TRAFFIC IMPACT STUDY

**Schmidt Rezone
El Paso County, Colorado**

August 2024

**Figure 2**  
**EXISTING TRAFFIC**  
 Volumes  
 AM / PM Peak Hour  
 (ADT) : Average Daily Traffic

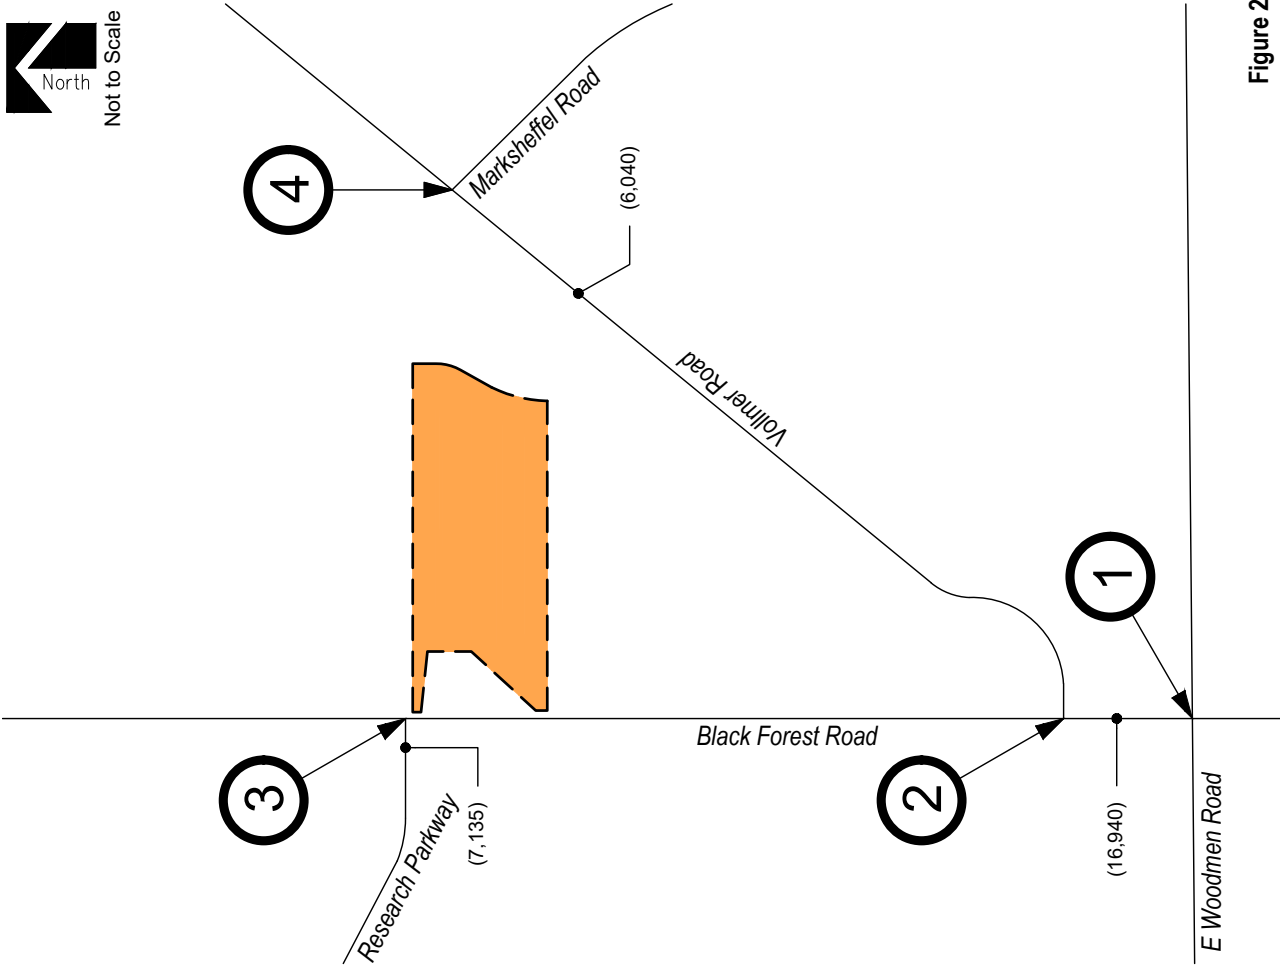
Can you describe whether construction was ongoing at this time.
